At this stage we **would not recommend discharge of conditions** until the following comments are addressed.

| DRAWING TITLE<br>PROPOSED SURFACE WATER DRAINAGE STRATEGY                                                                         |          |                     |  |                    |    |                |     |

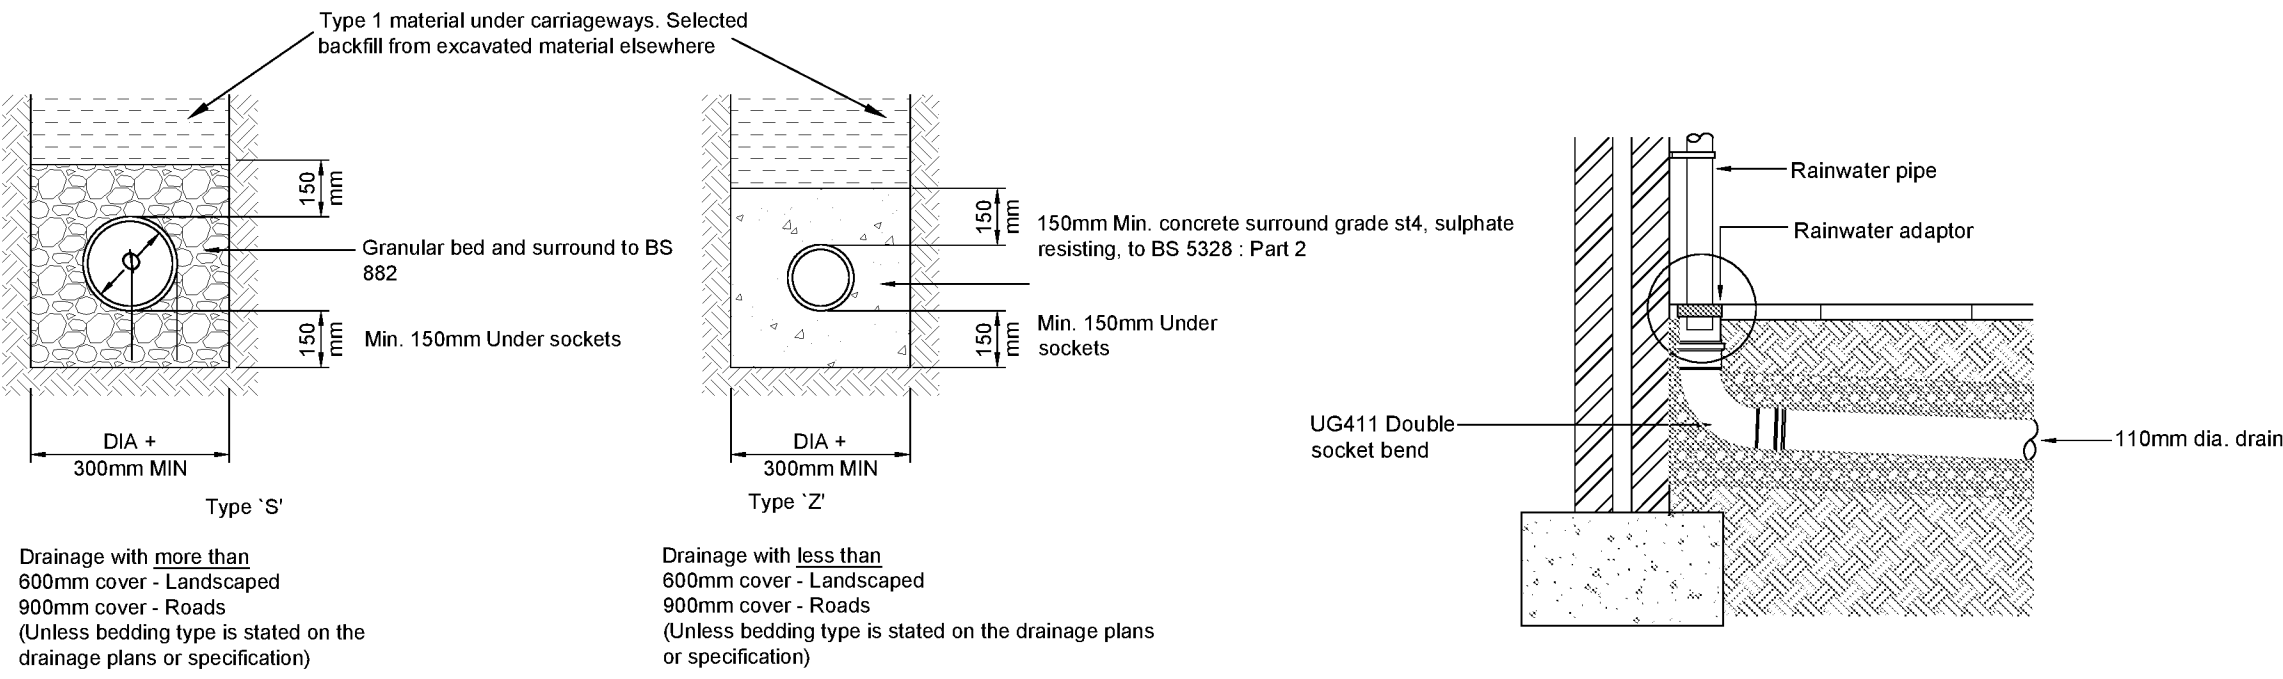
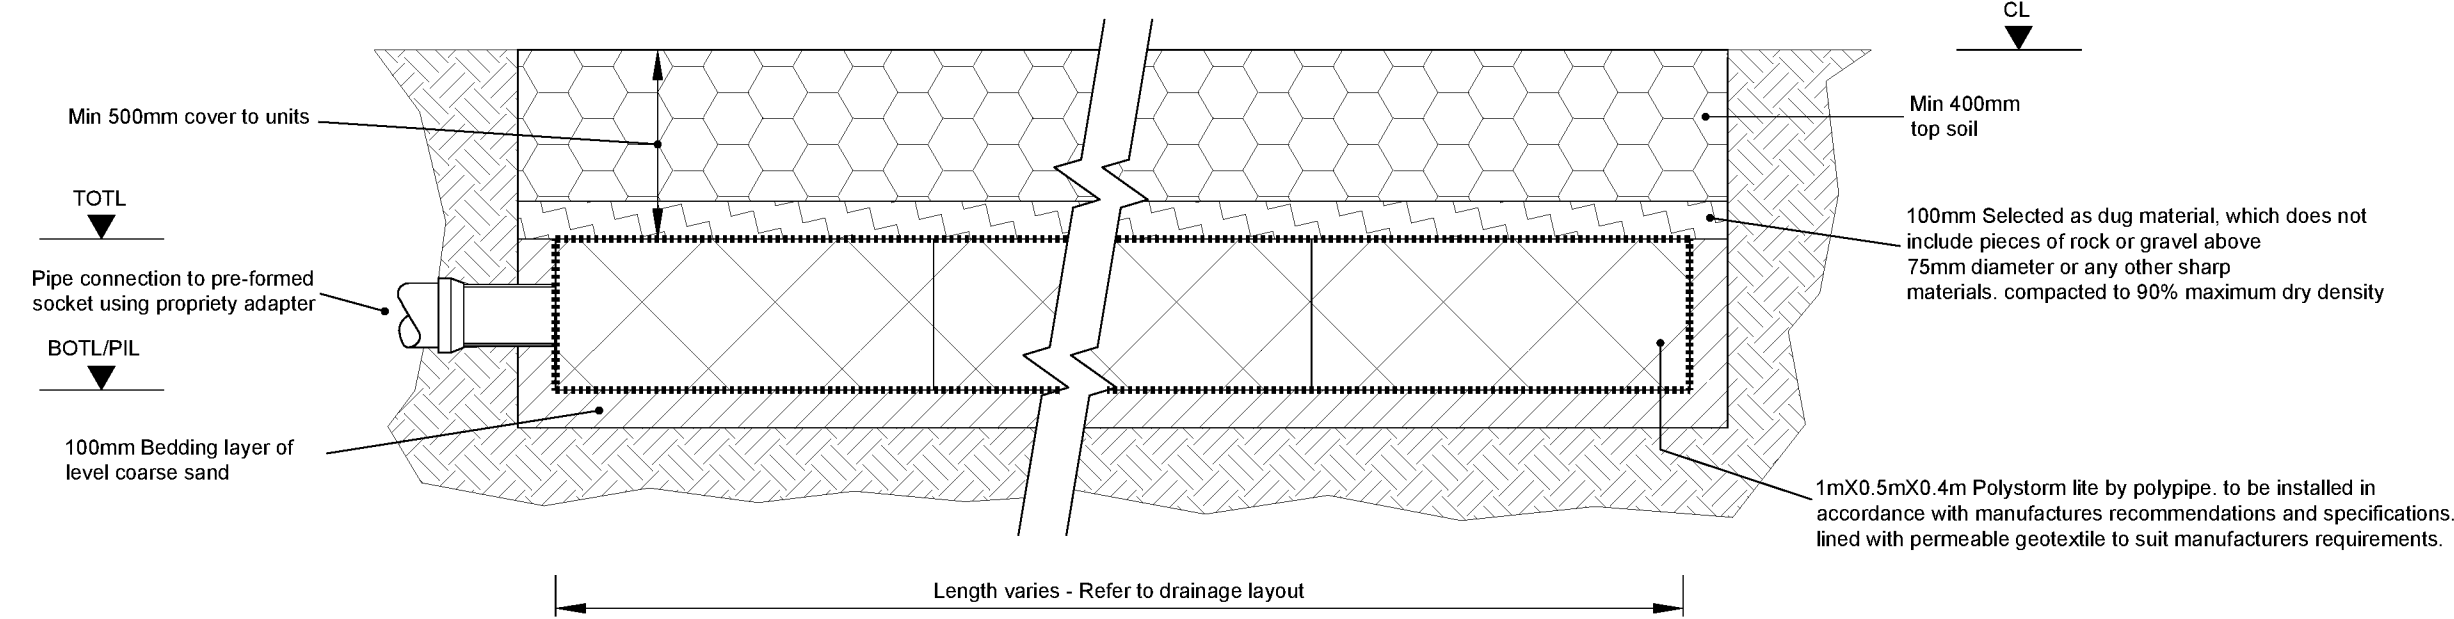
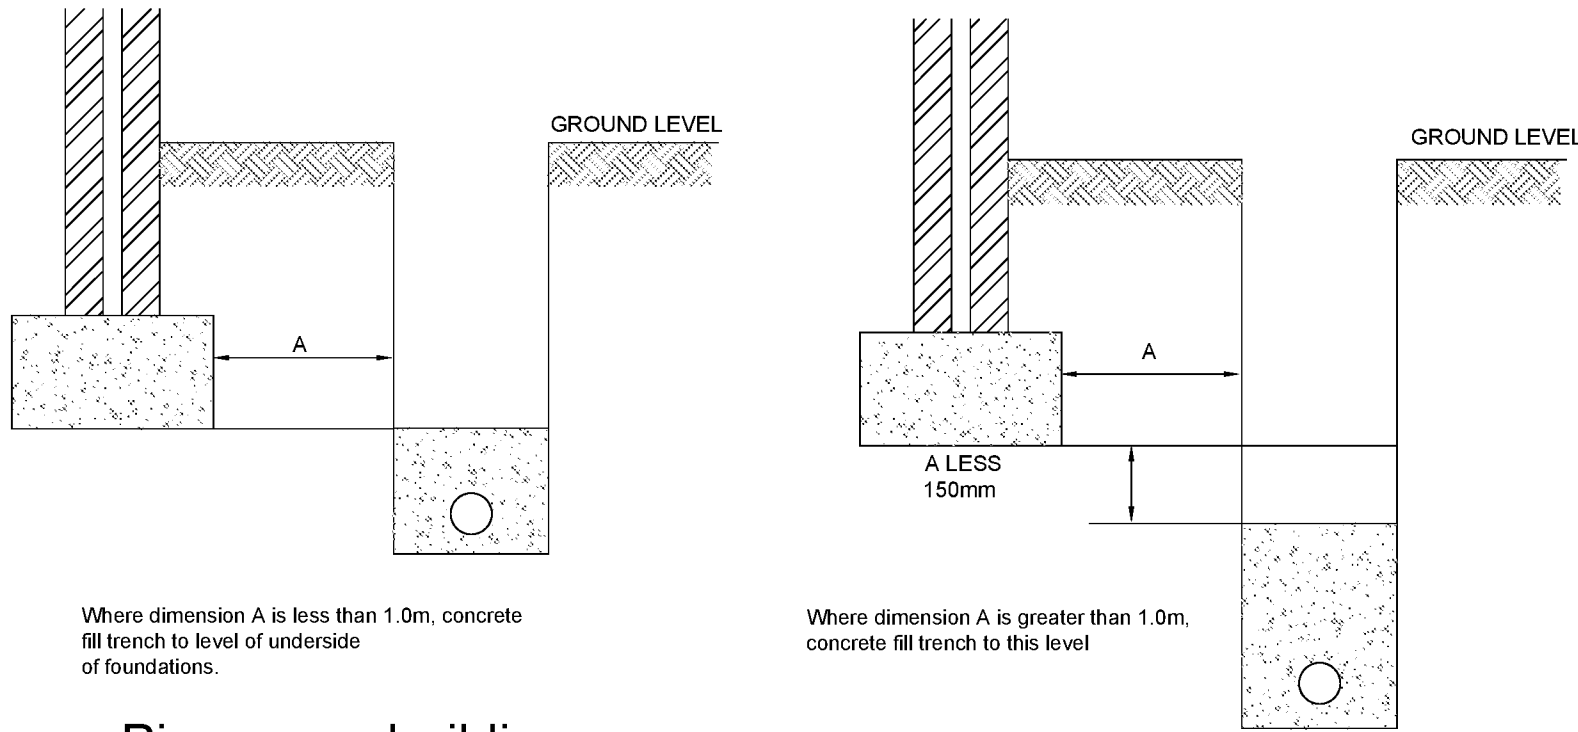
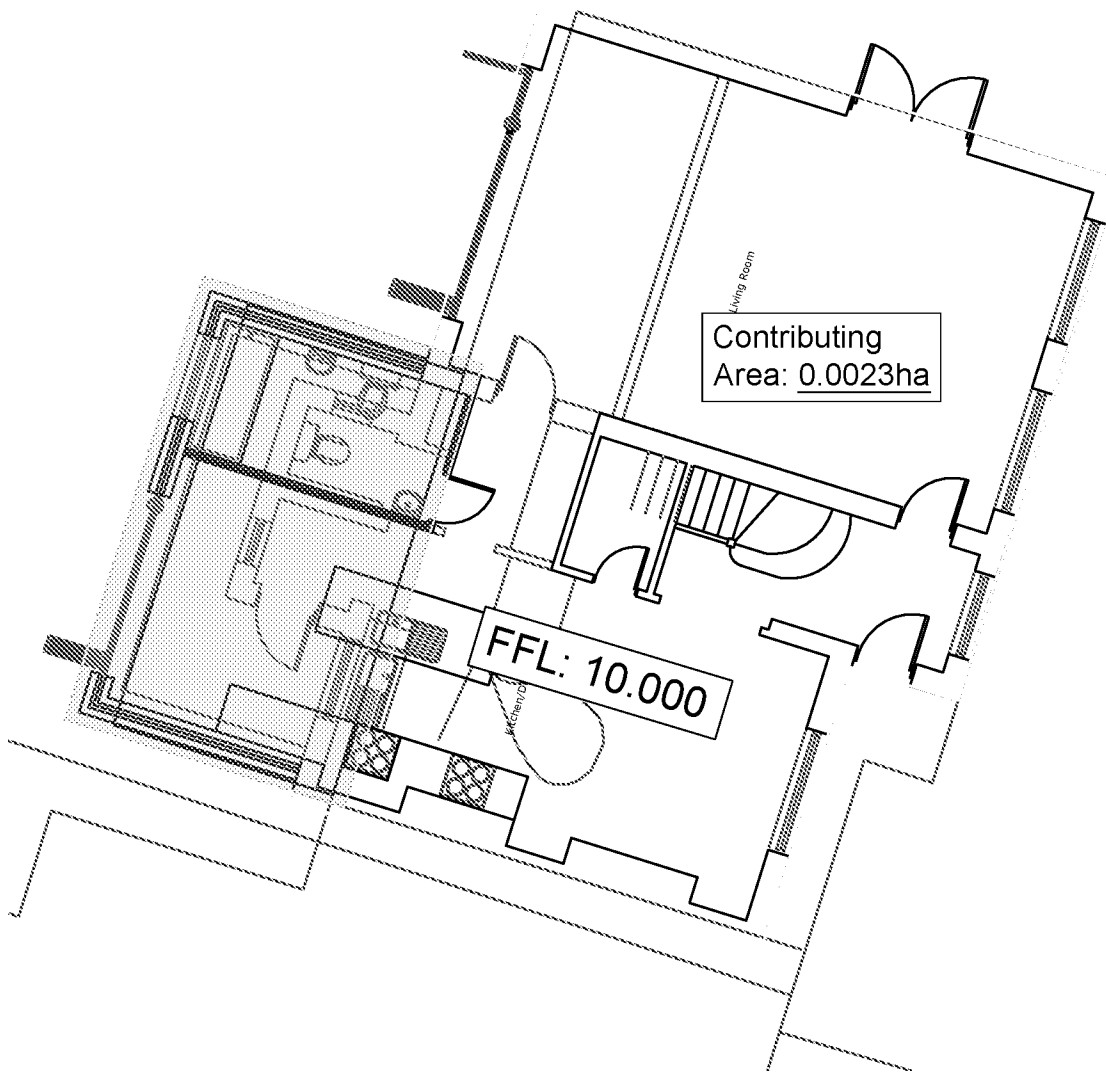
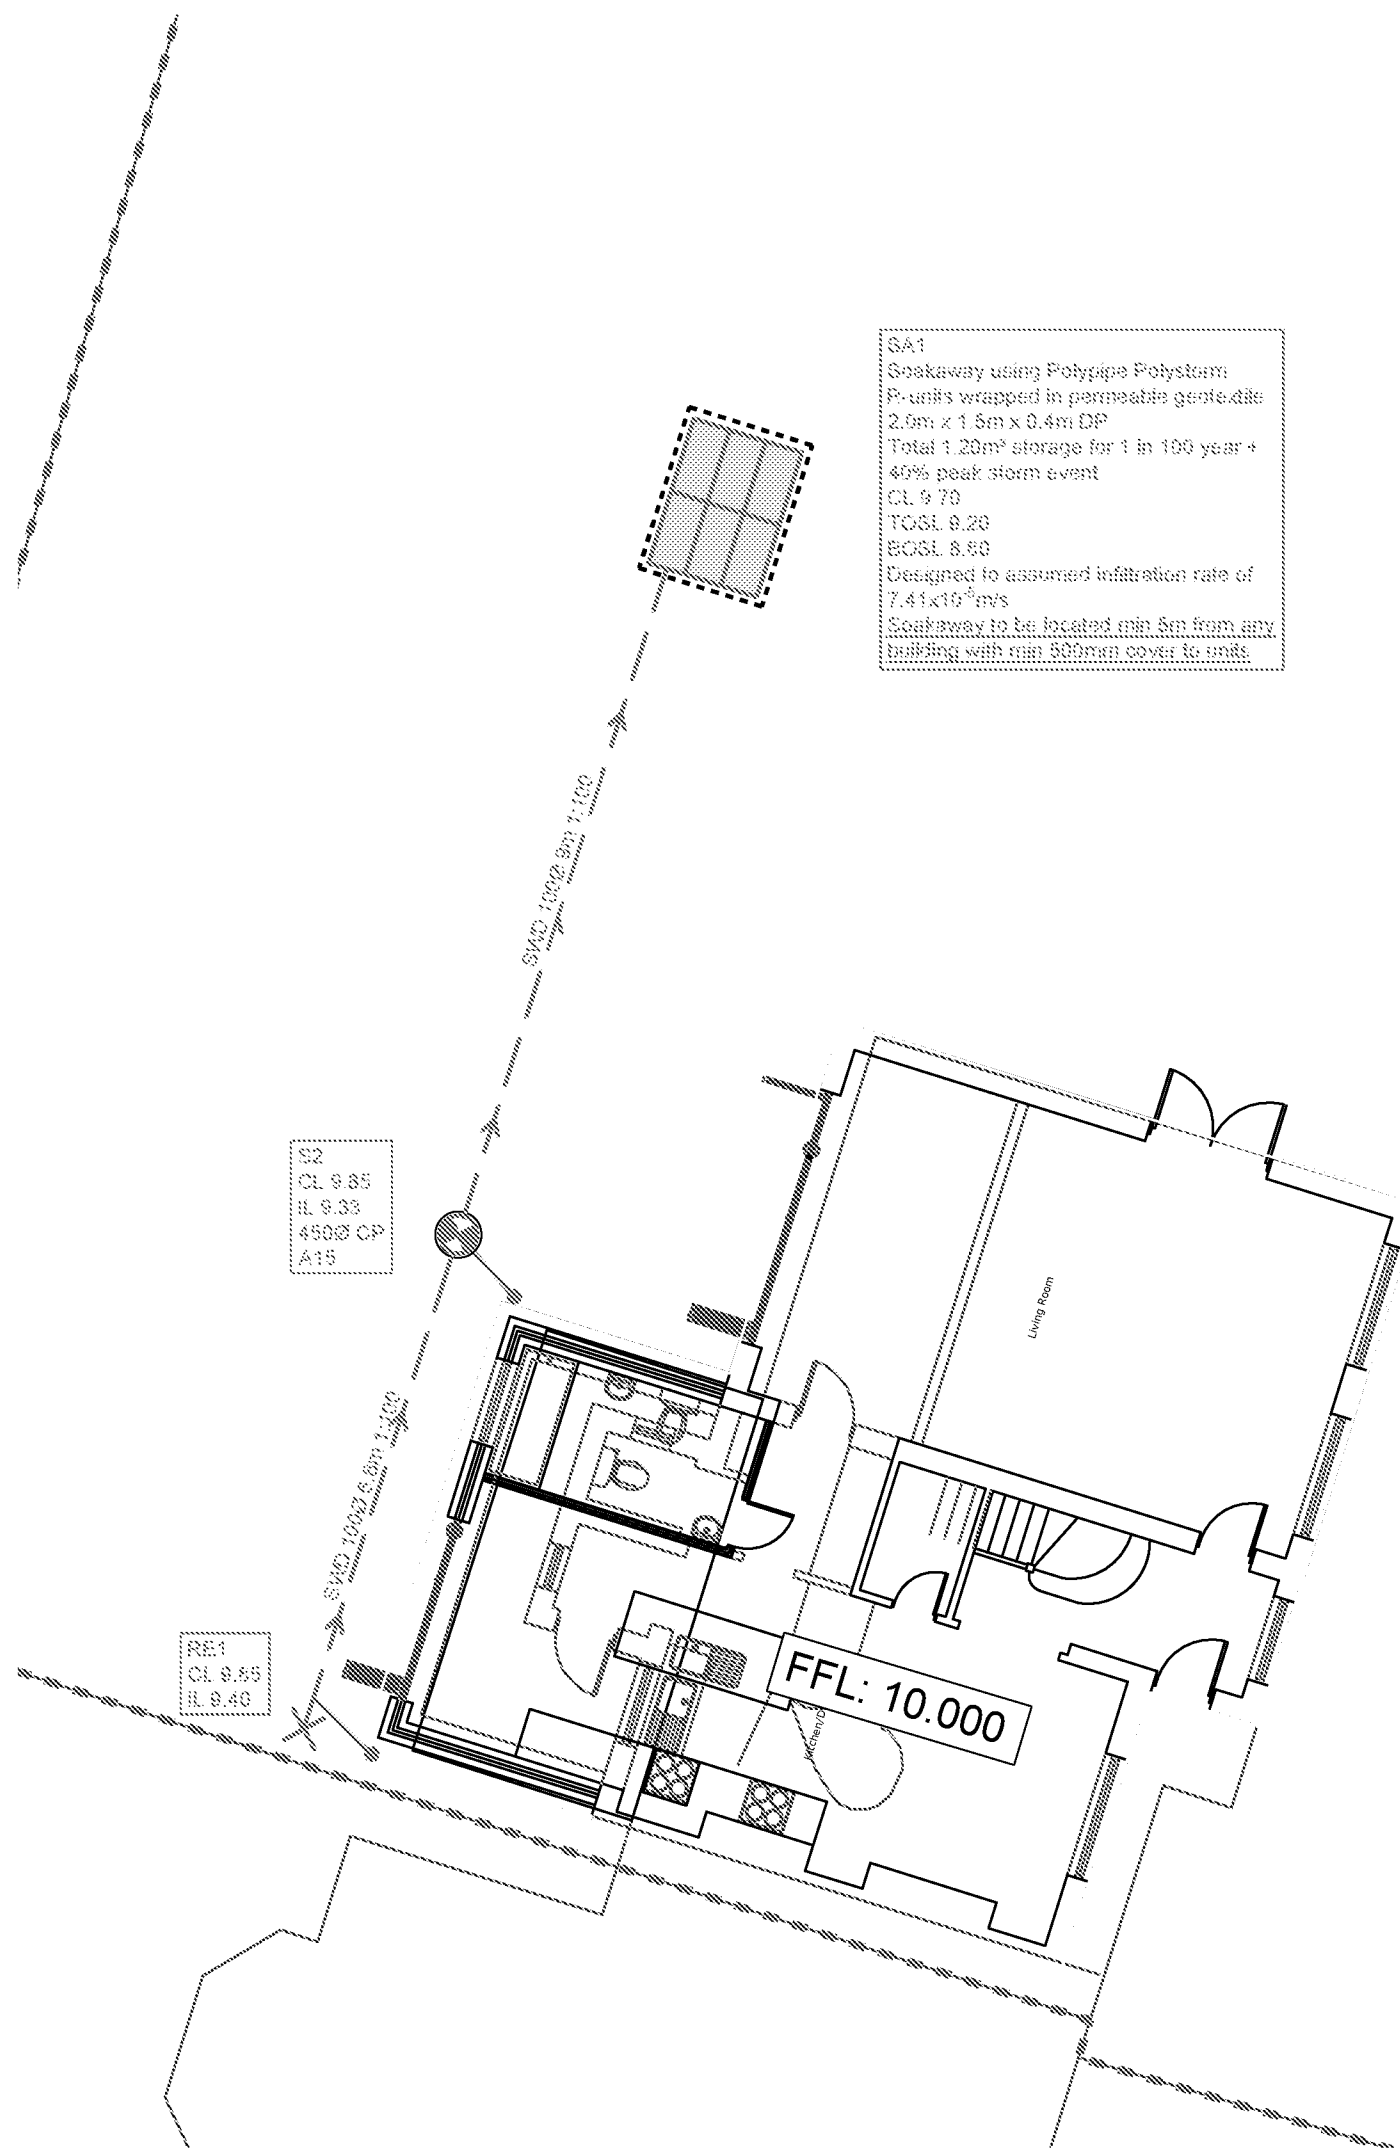
1. Additional information is required on the design drawings.
 - The loading class for the cover on the sediment trap manhole (and any other manholes) should be stated.

- The access point for carrying out maintenance and inspection of the soakaway should be stated, (and details given if this is an additional element of the design e.g. additional manhole).

4. The incoming pipe invert level is potentially below the 1:10 year water level within the soakaway. The applicant should confirm that the pipe is not likely to be surcharged during the 1:10 year storm. Or the pipe could be raised to provide a larger difference between the soakaways invert level and the pipe inlet invert level, or additional crates included within the design, to lower the 1:10 year water level.

5. The applicant should confirm that the soakaway is outside of the root protection zone (RPZ) for the trees located on the land where the soakaway is proposed.
